RE: Jones Variance (VA-25-00004) - Deemed Incomplete
Parcel #520234

Dear Applicants,
Kittitas County Community Development Services received your Zoning Variance application on July 2, 2025. The application has been determined **incomplete** as of July 14, 2025.

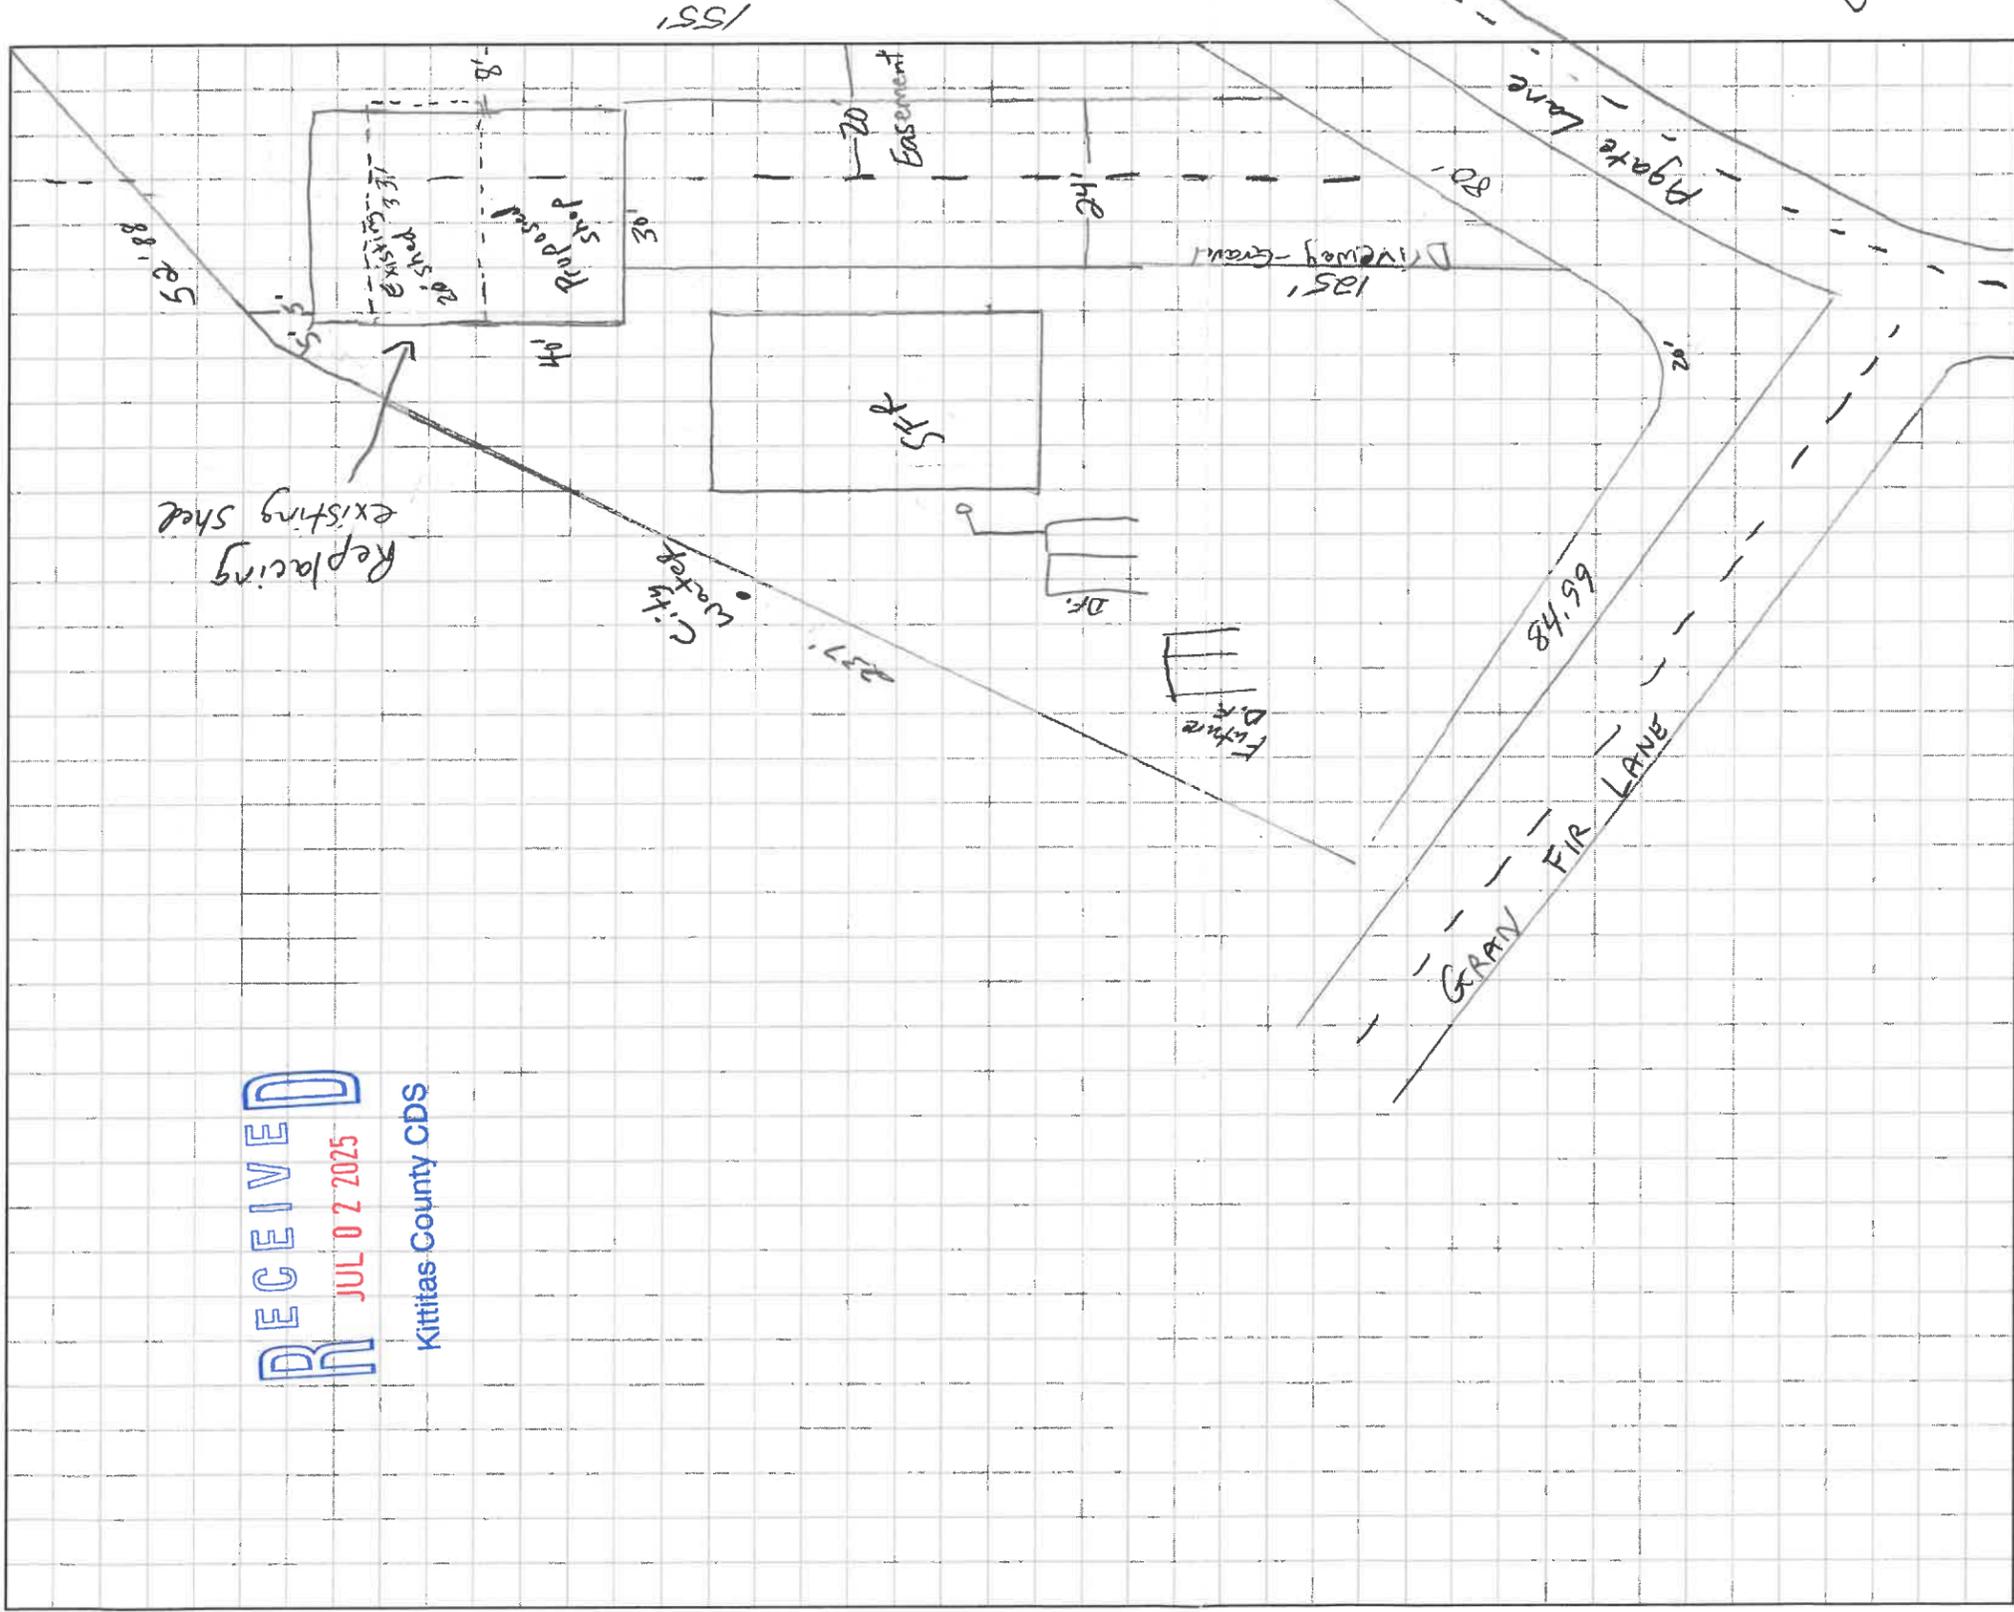
1. Corrected Site Plan:
 - a. It is stated in your submitted narrative that the structure is being replaced in the "same place." Your site plan shows that the structure is actually increasing in size.
2. Narrative:
 - a. In accordance with the requirements stated on the front of the submitted application, your narrative needs to include the project's size in terms of square footage.
 - b. Your location within the application is missing the Township regarding Section/Township/Range.
 - c. Your narrative is missing the specific section of Kittitas County Code that you are requesting a Variance from and in what way you wish to vary from the Code.
 - d. Your narrative is missing the entirety of "Question 10," which contains the Variance Checklist. This section asks you to explain the case you wish to make for why this Variance from Kittitas County Code should be allowed.
